From: Tom Wessely <[REDACTED]>
Sent: 02 September 2021 16:36
To: Simon Davis
Cc: David West; Andy Mckeown-Mundy; Ian Johnson
Subject: Re: Condition 5 ref. Y/97/21/DOC
Attachments: Plots 1.2.3.20.21 _ Elevations.zip

Typical detail
Window head sill and jamb
in brick elevation

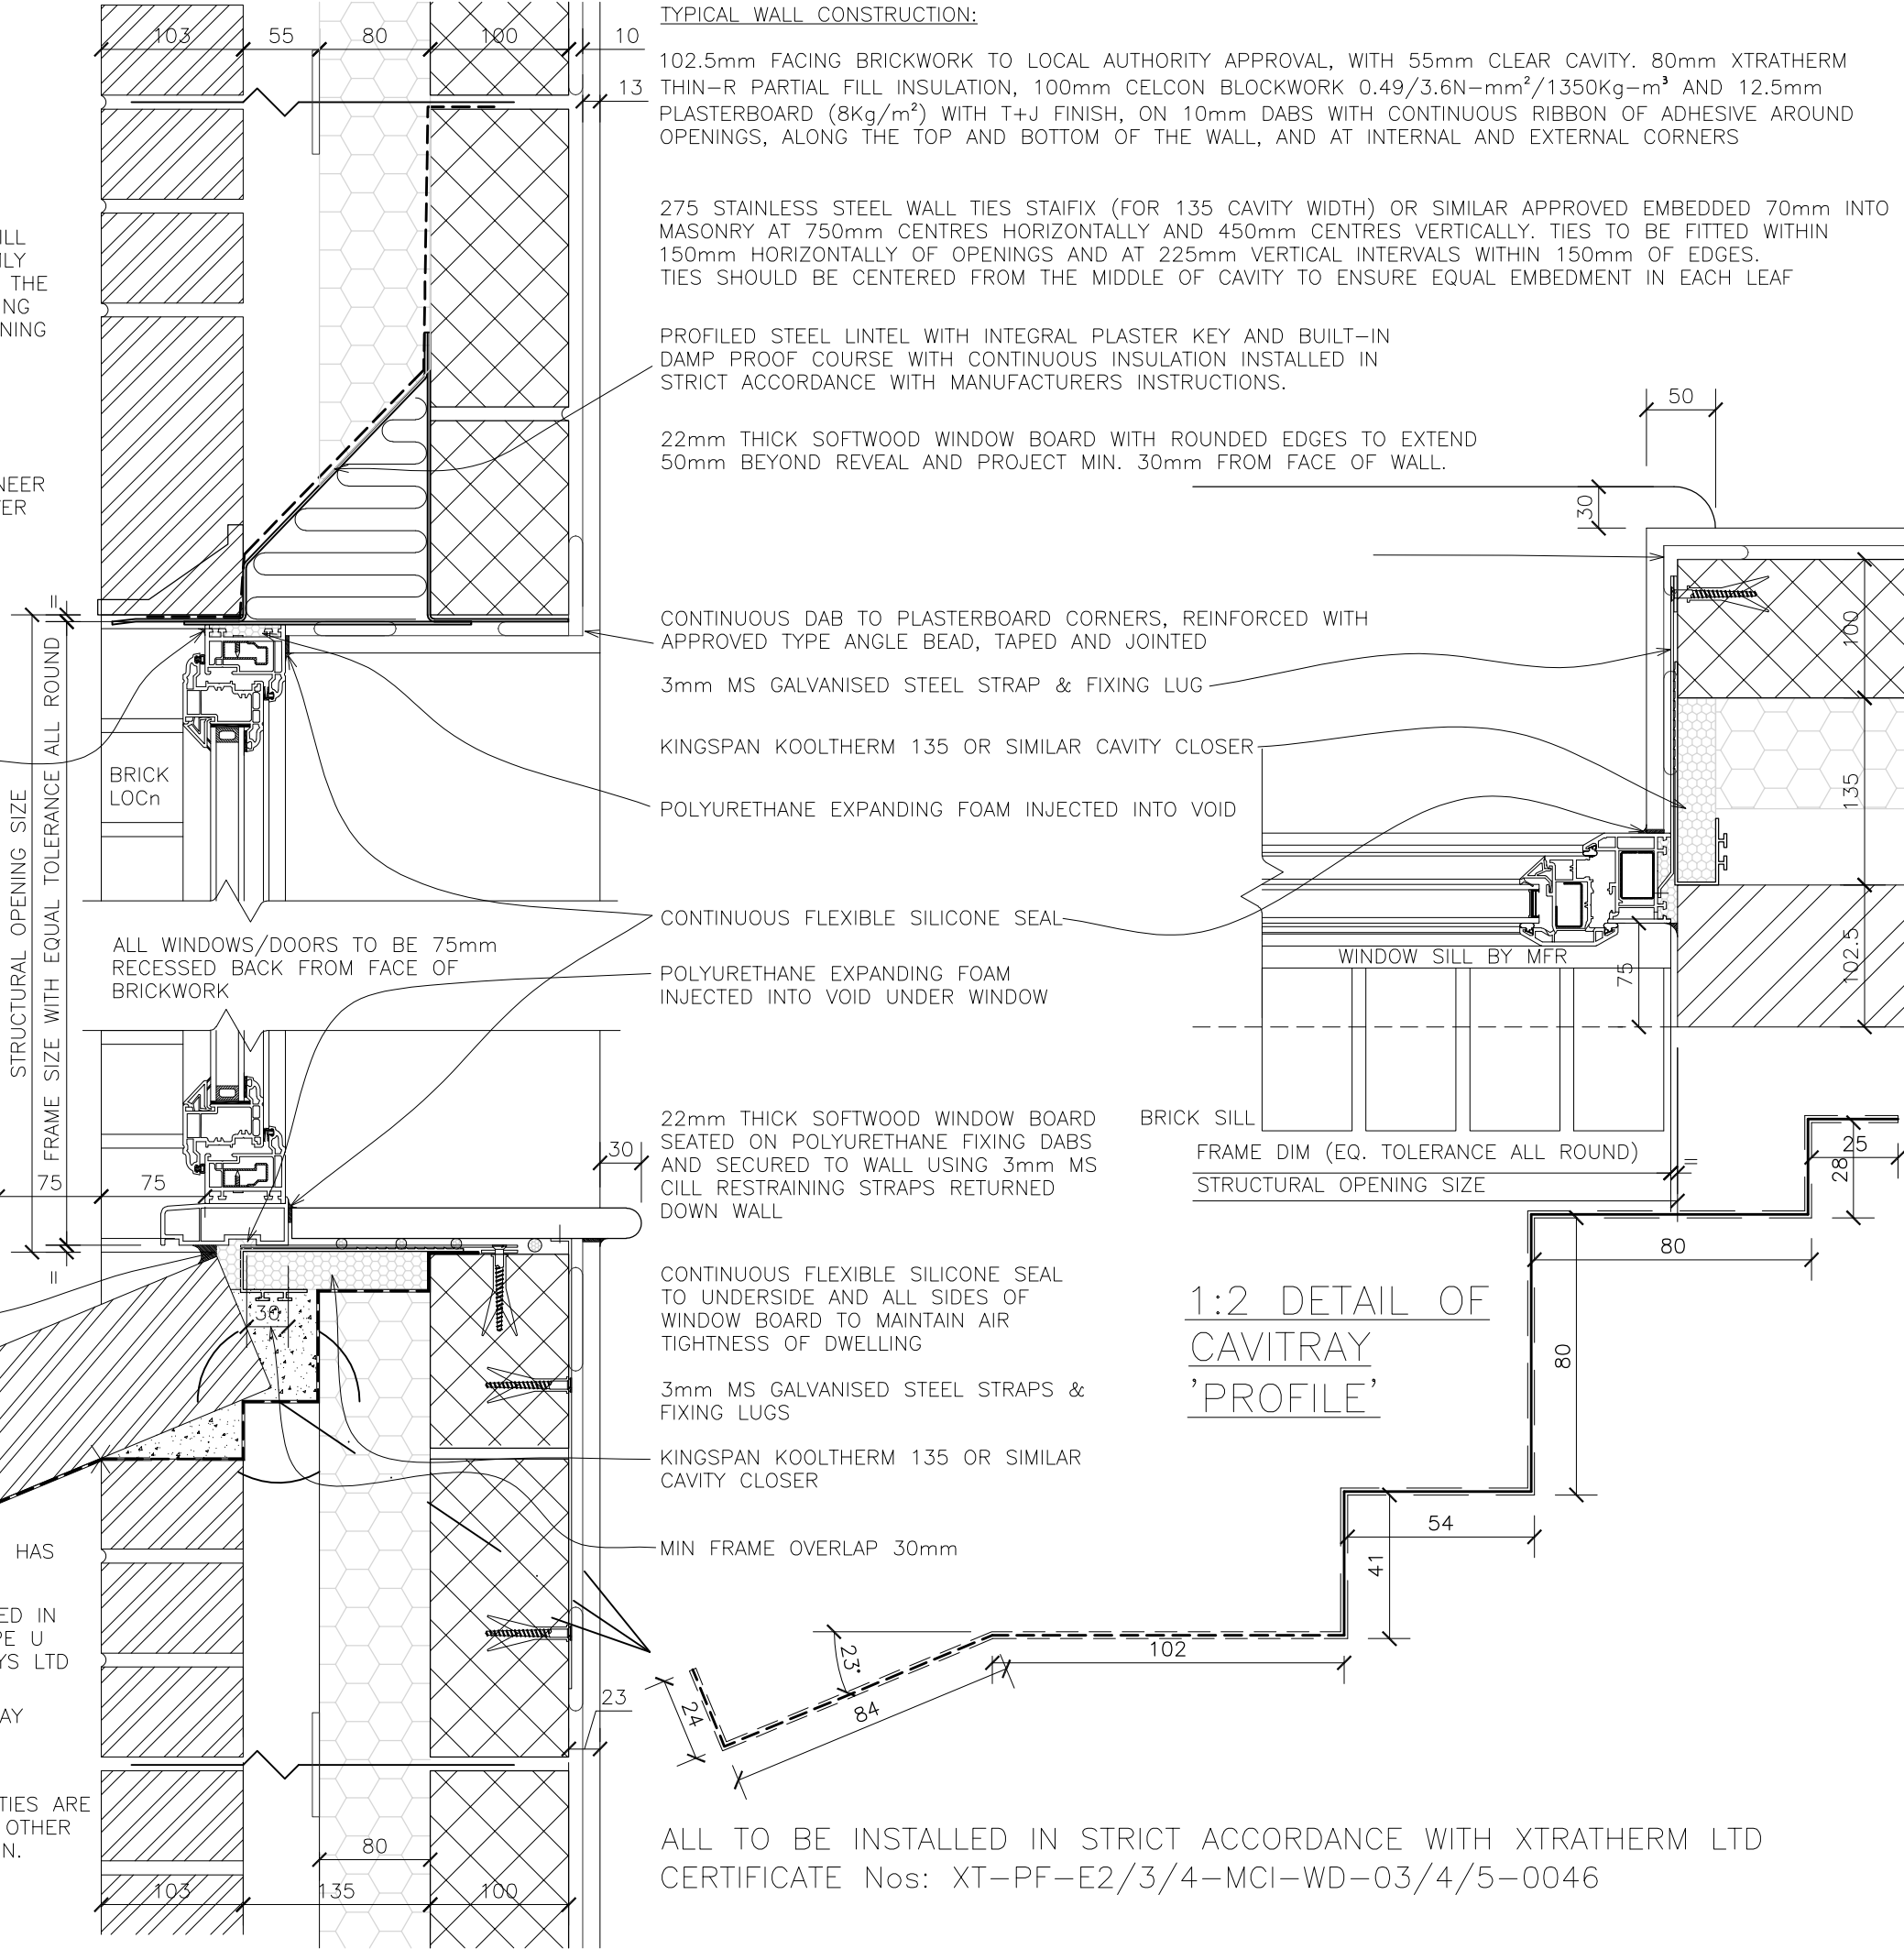
Firstly, when you submitted those additional plans I superseded the existing submitted plans including the following two:

TYPICAL DETAIL WINDOW HEAD SILL AND JAMB IN BRICK ELEVATION 0188 REVP01
TYPICAL DETAIL WINDOWS HEAD SILL AND JAMB IN TILED ELEVATIONS 0189
REVP01

Excuse the caps, I have copied the text from our system. Should I not have superseded these? Please advise.

I can confirm that you should not have superseded those drawings. They were submitted to discharge this condition and have not been replaced.

General Arrangement
Elevations
Plot 2

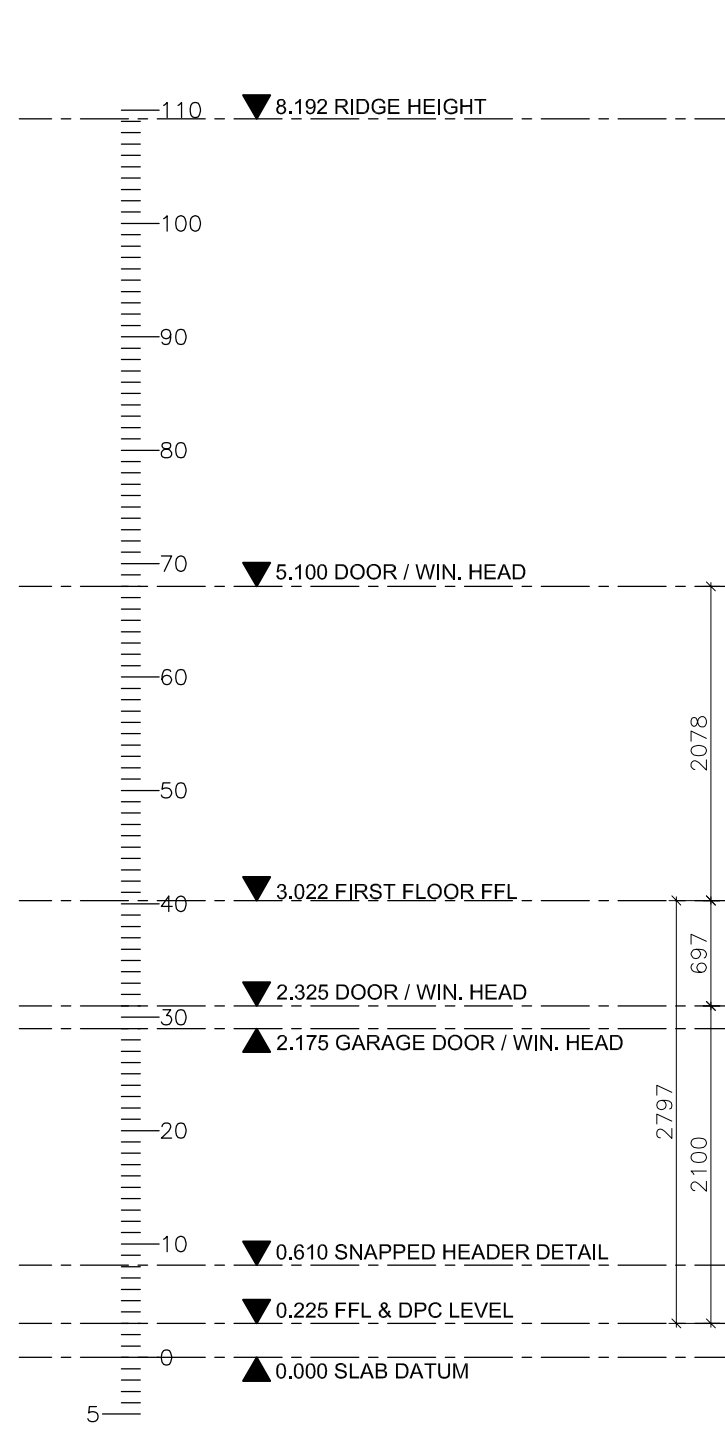
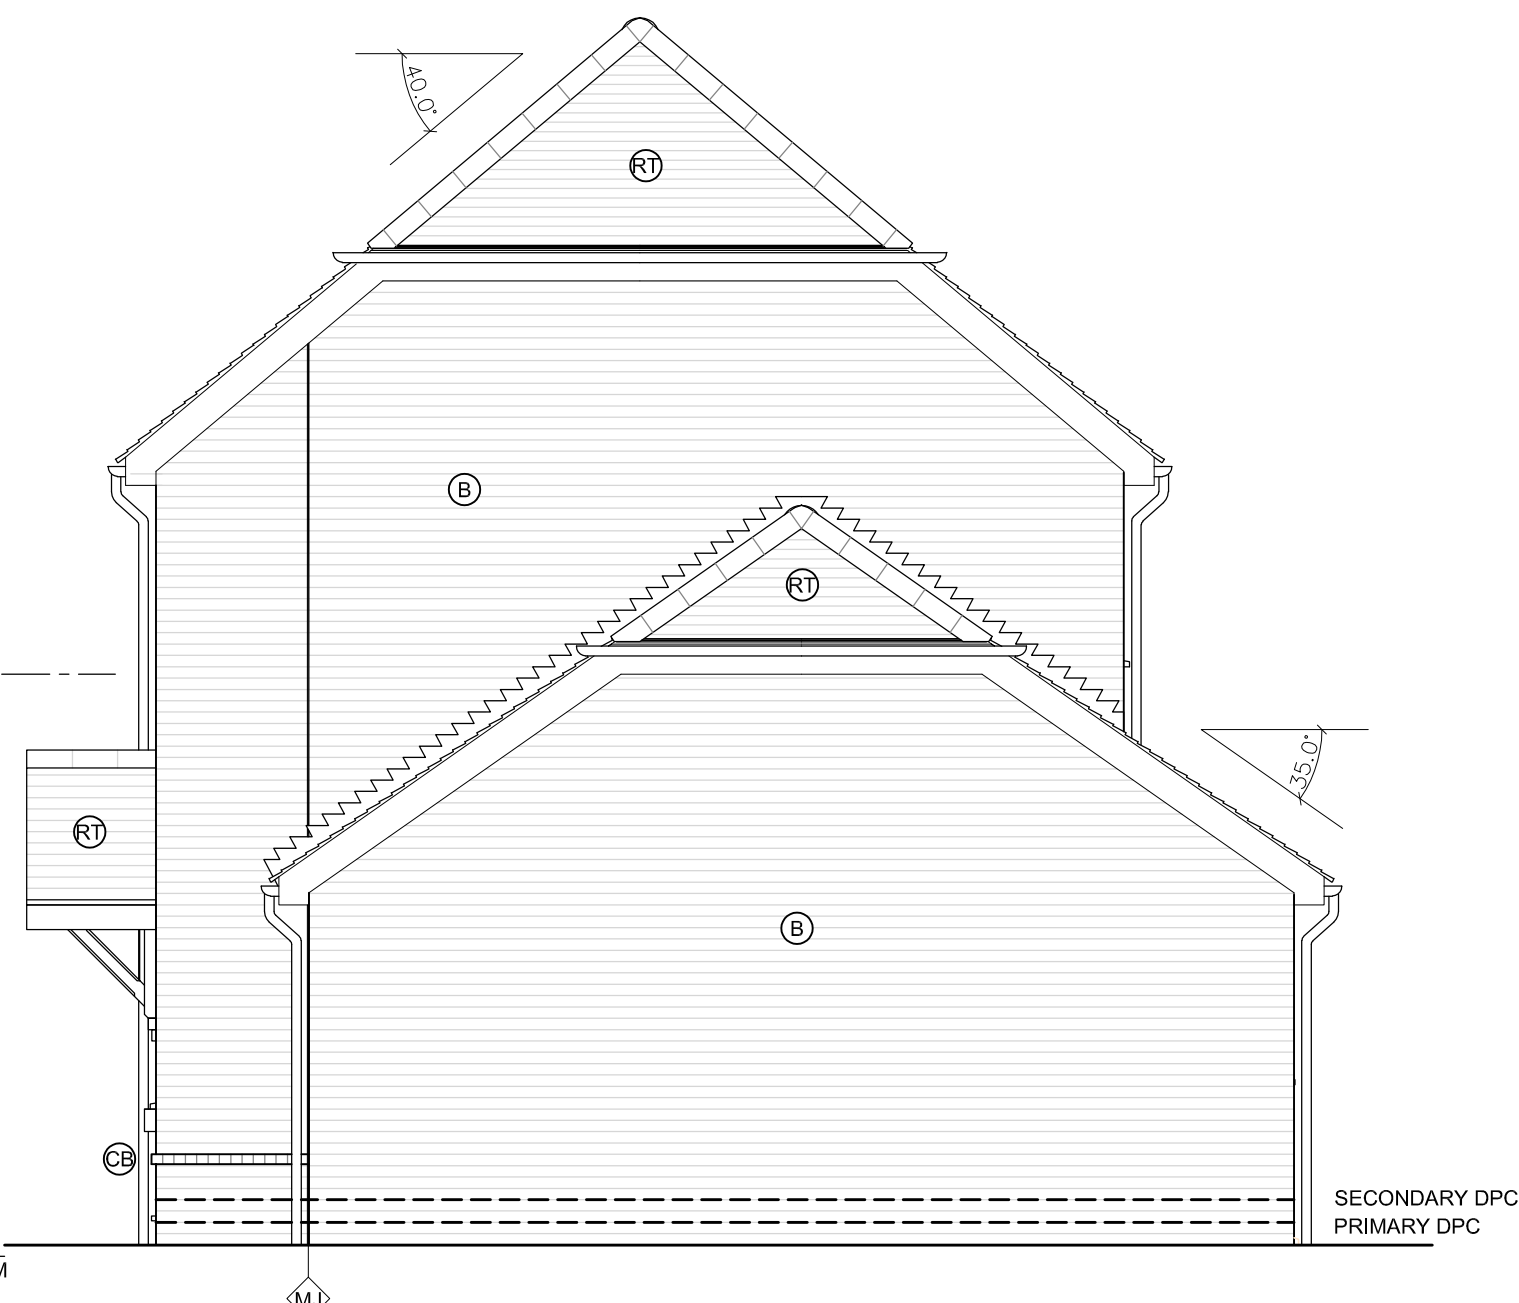
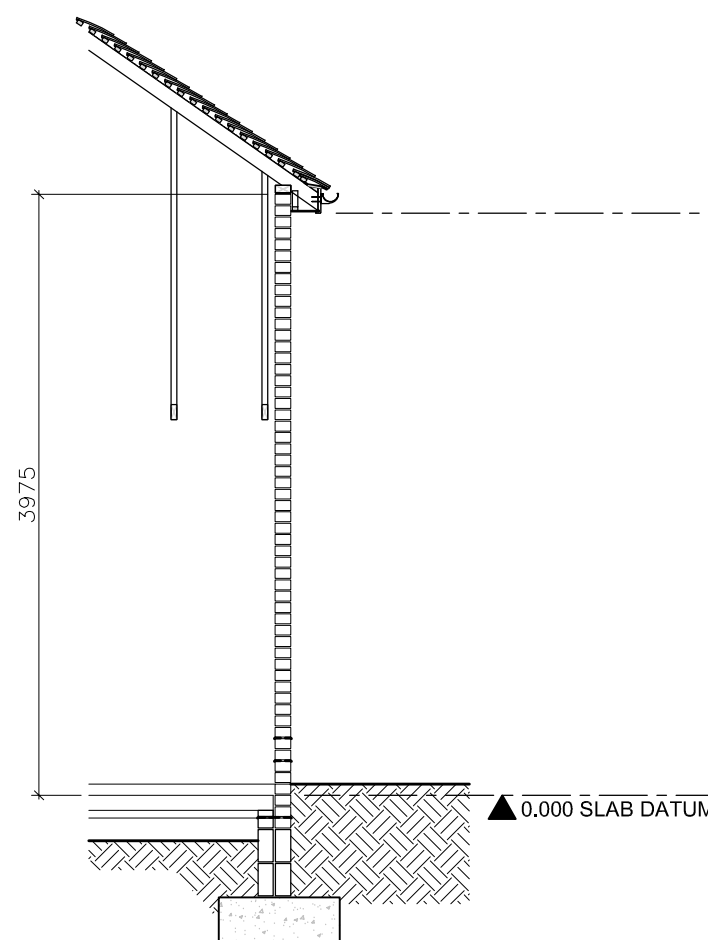
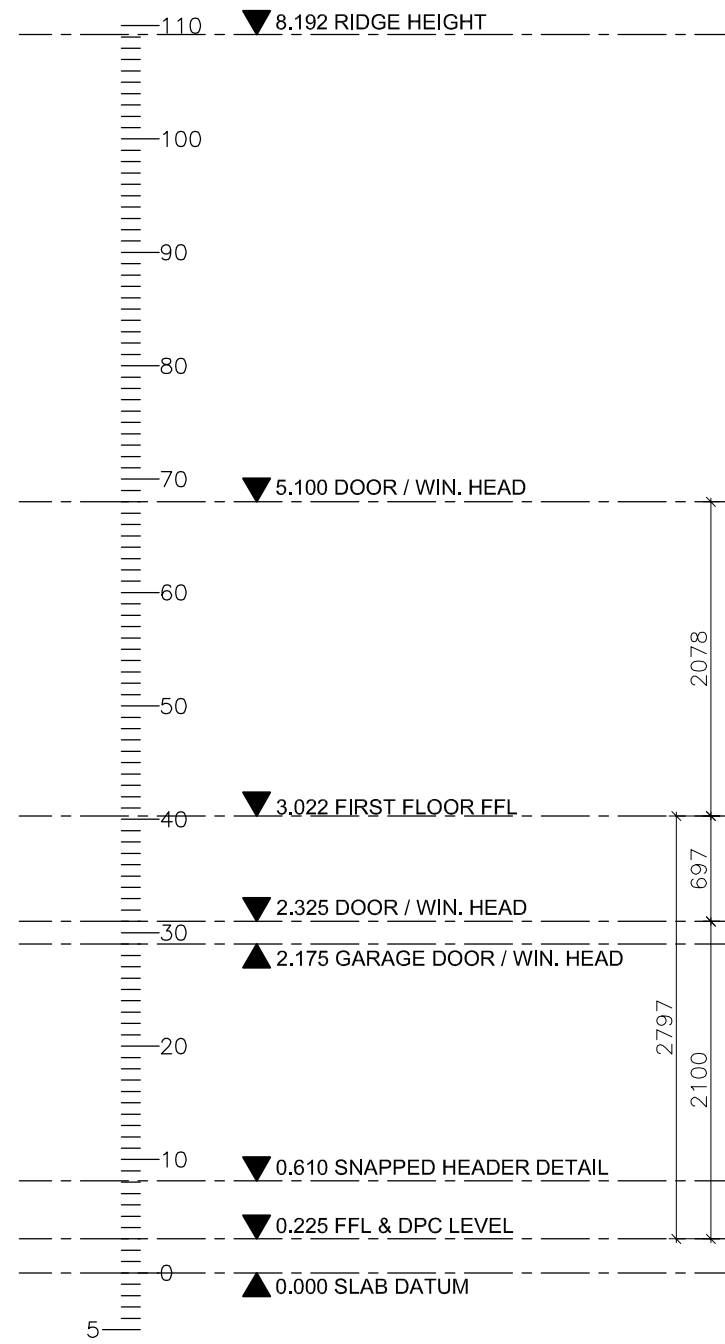
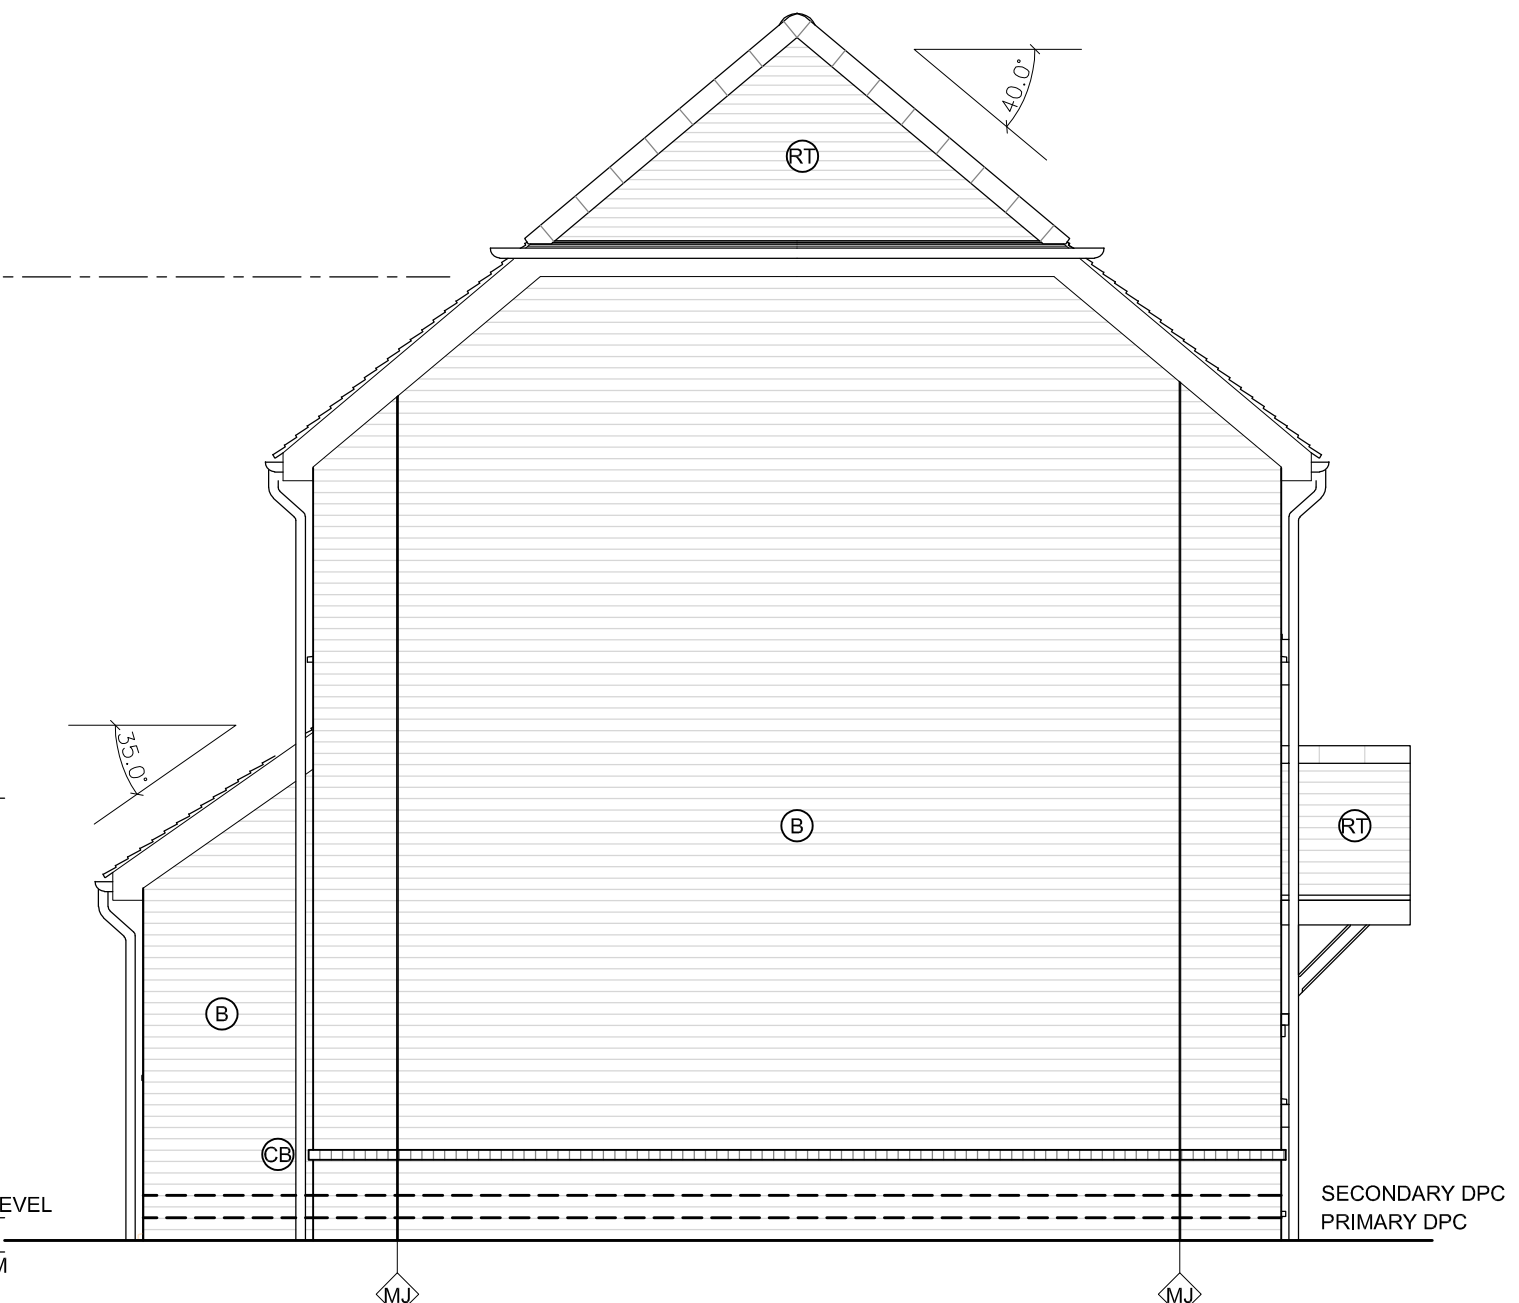
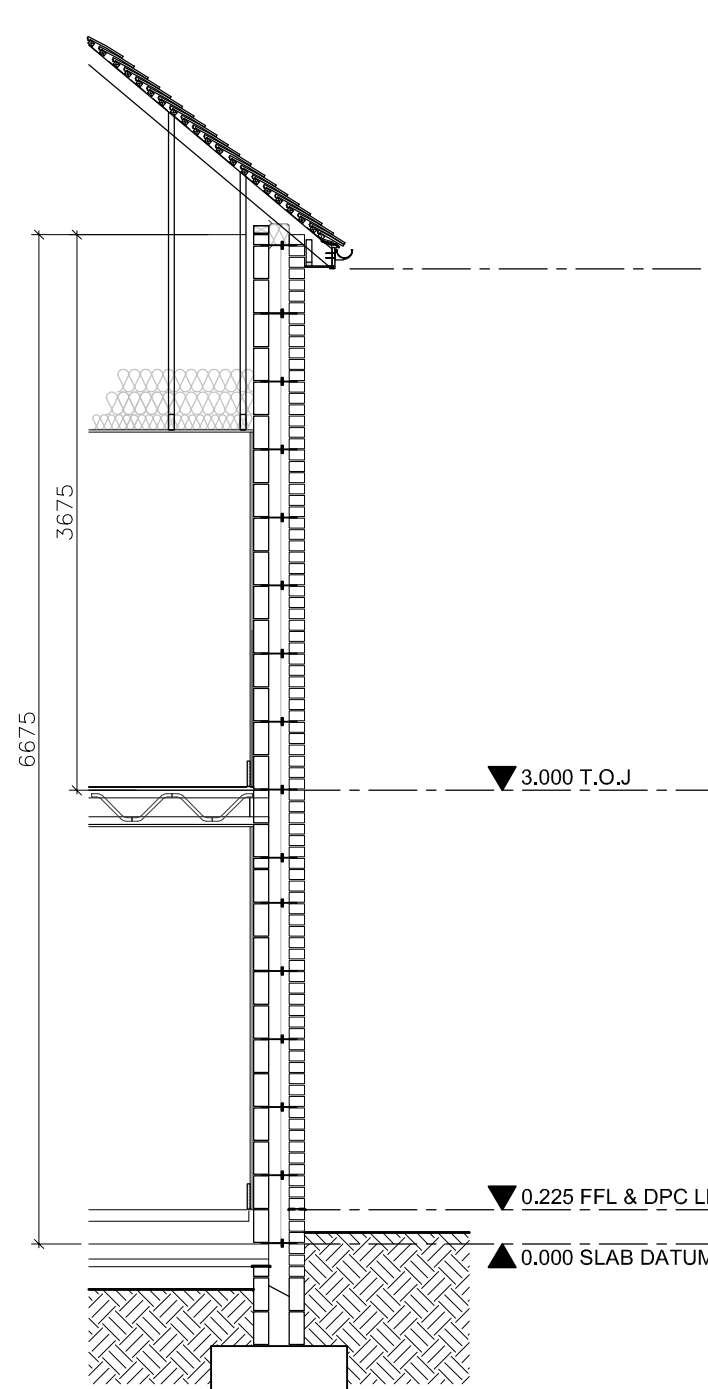
Secondly, we have no plans referring specifically to plots 1, 2, 3 and 19-21 which are named in the condition. Can you advise the position in respect of these? Are they covered by the above plans? If they are then its not clear from the drawings.

Please see enclosed elevations for plots 1, 2, 3, 20 and 21. I am not in a position to provide you with the drawing for plot 19, however I can confirm that this plot will also have white painted timber windows.
